TRAFFIC IMPACT STUDY

Western Drive Townhomes
El Paso County, Colorado
PCD File No. PPR2415

September 2023
Revised October 2023
Revised November 2023
Revised June 2024

This traffic impact study has been revised to address County review comments dated 04/23/2024 regarding an updated density and minor text updates throughout.

L3

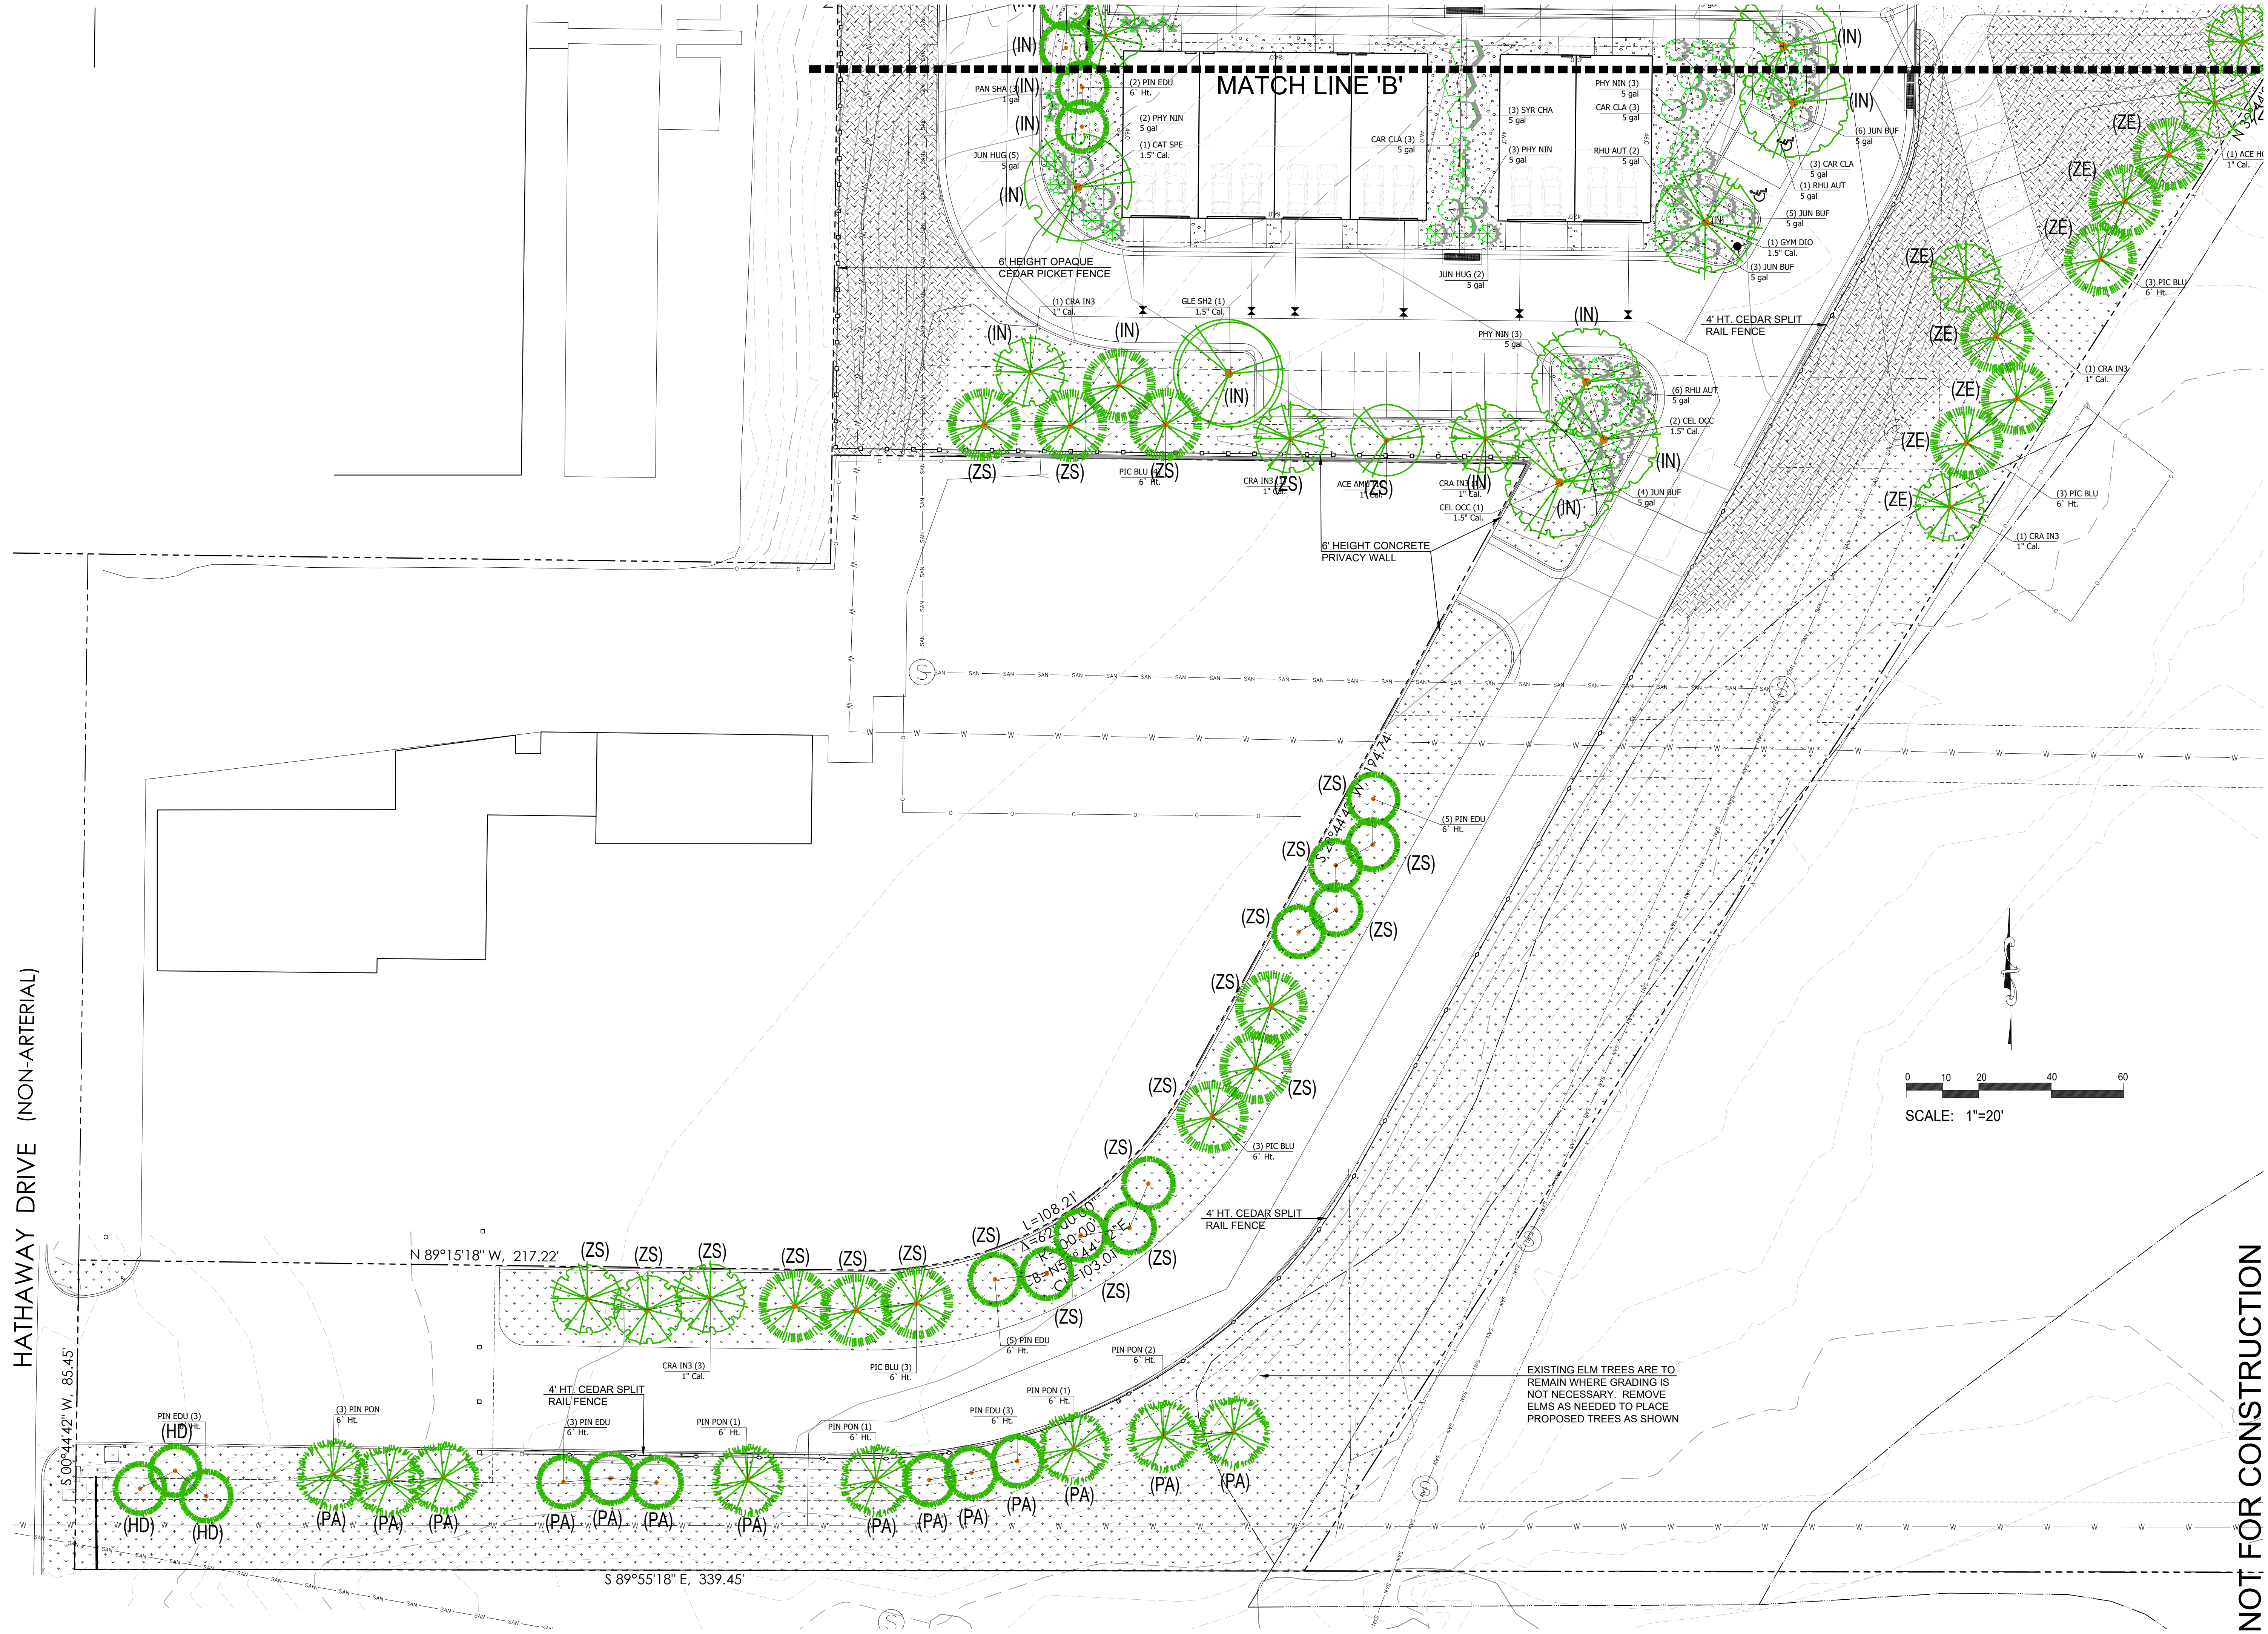
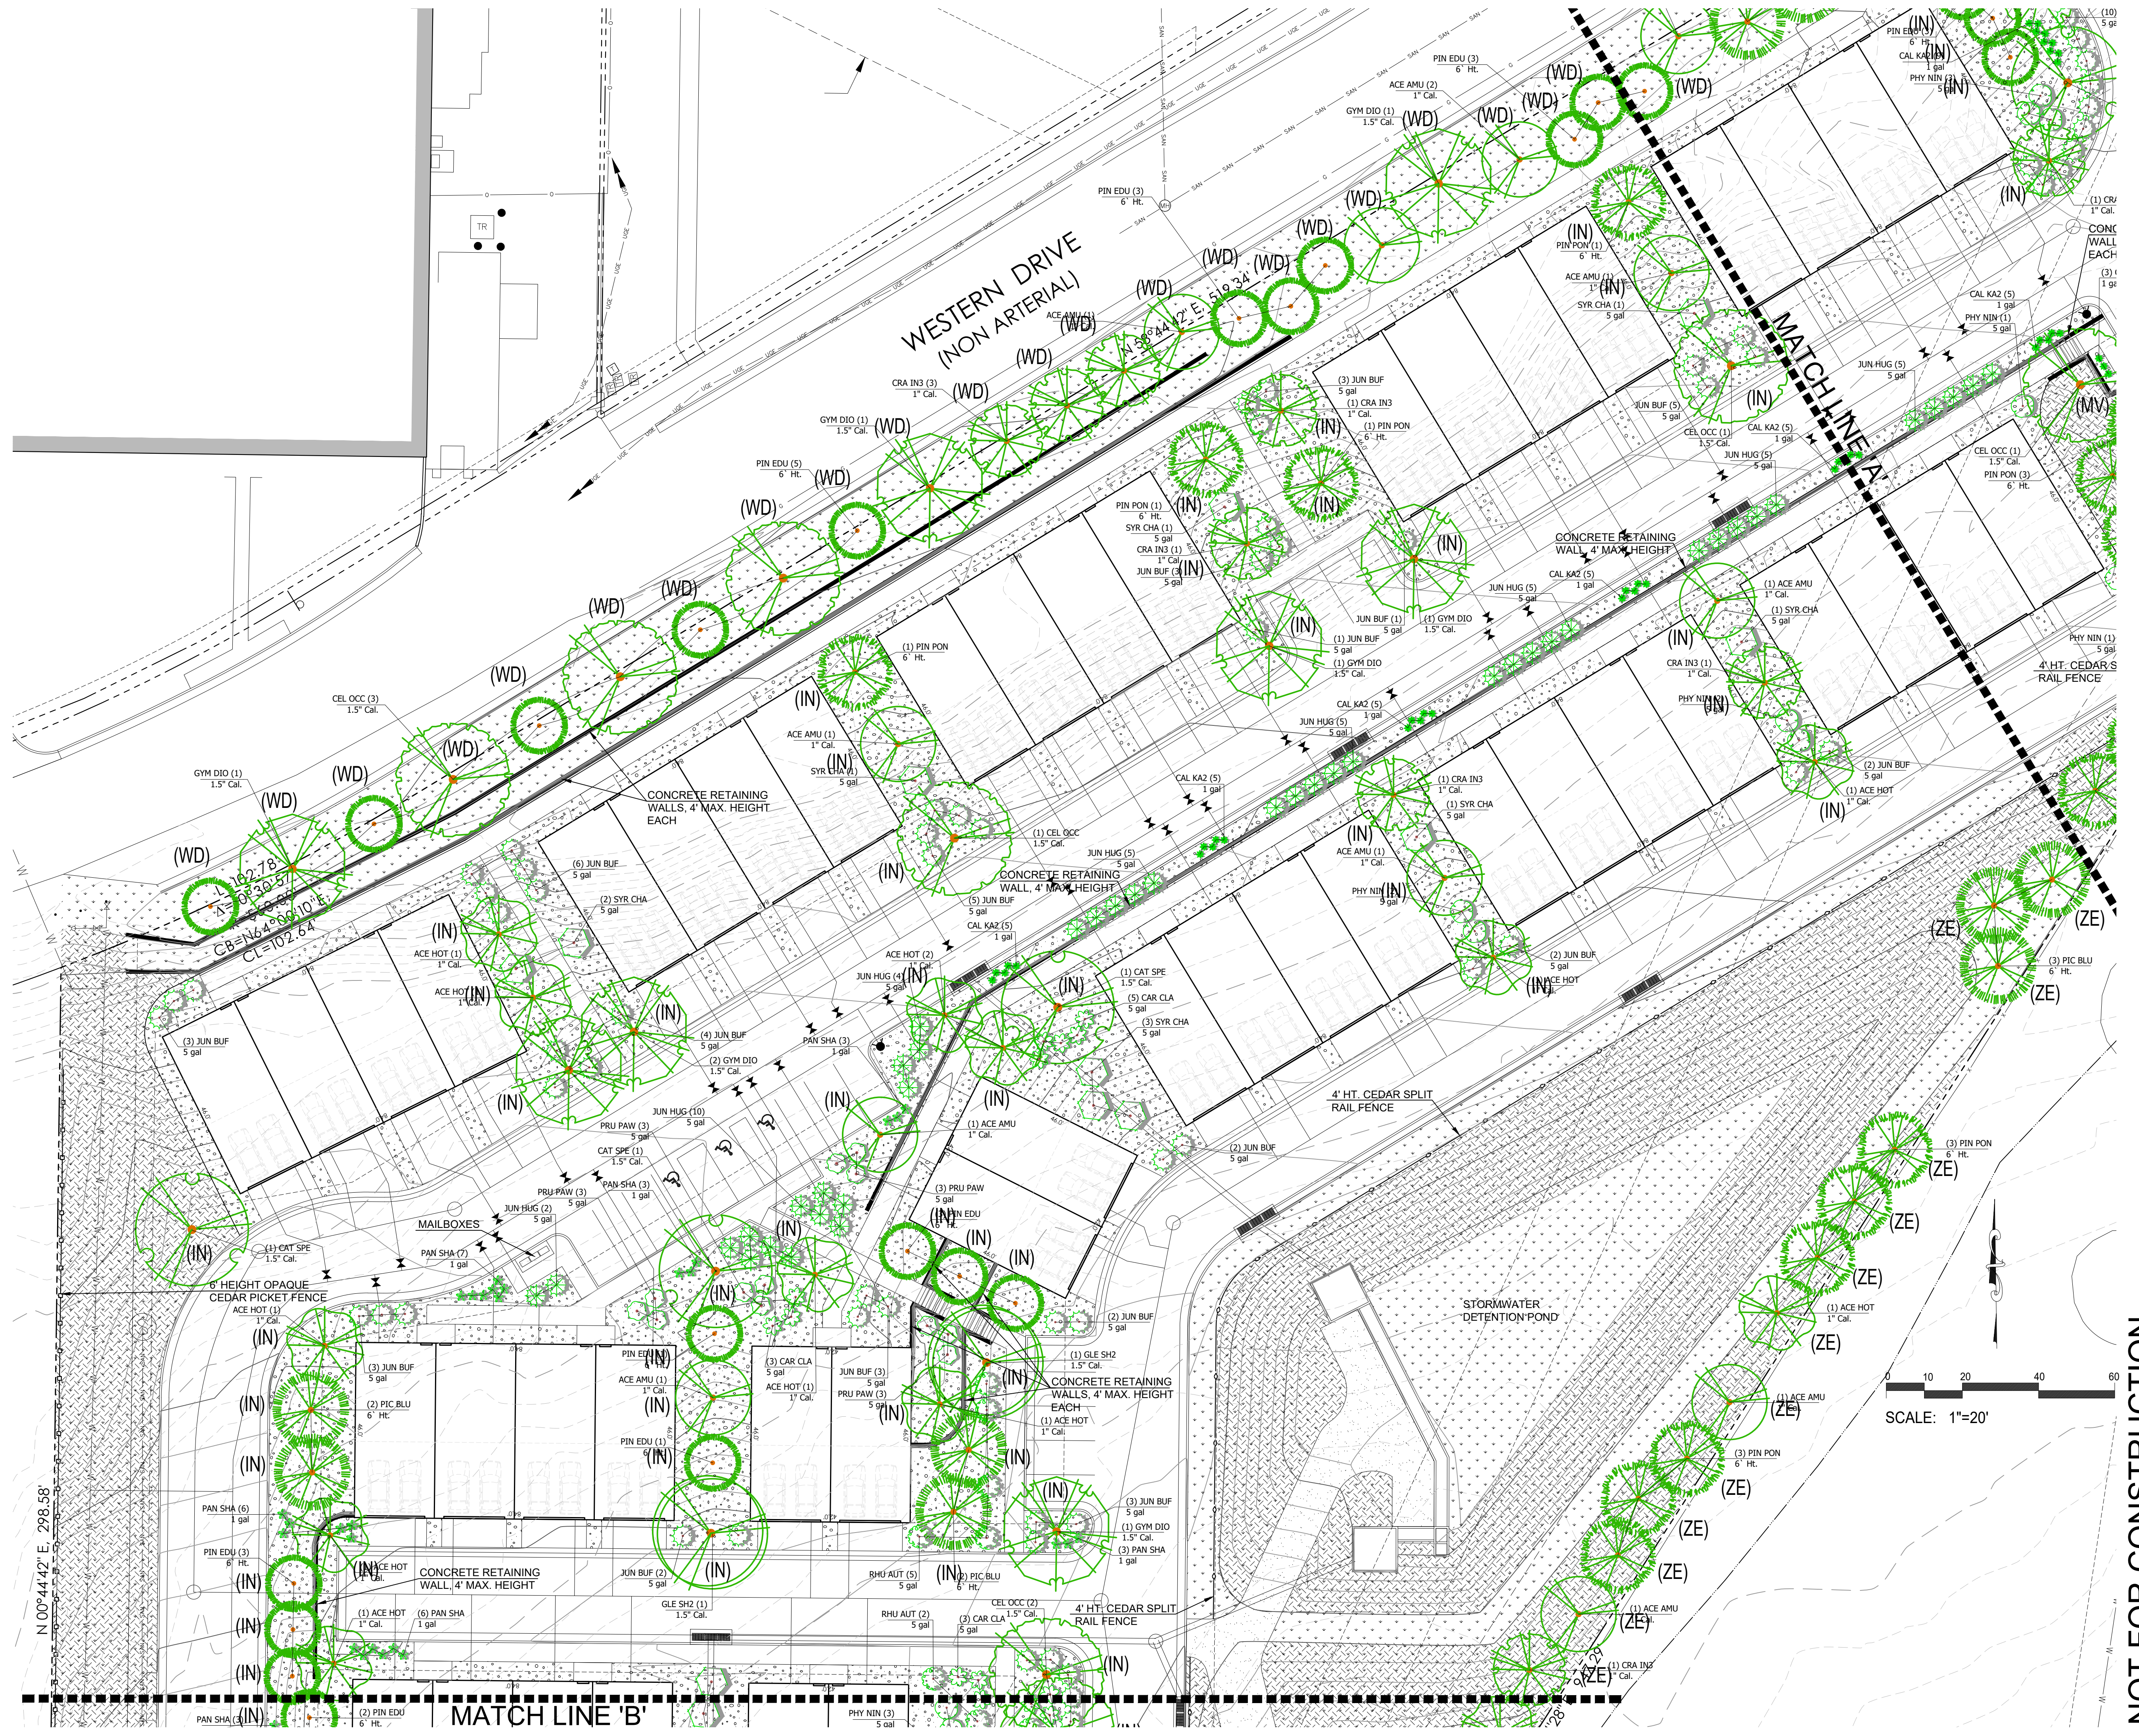
Review C1: Provide sight distance exhibit for other access location.

Review C2: Unresolved. This is landscape exhibit, not sight distance exhibit. Please provide sight distance exhibit for access A and B.
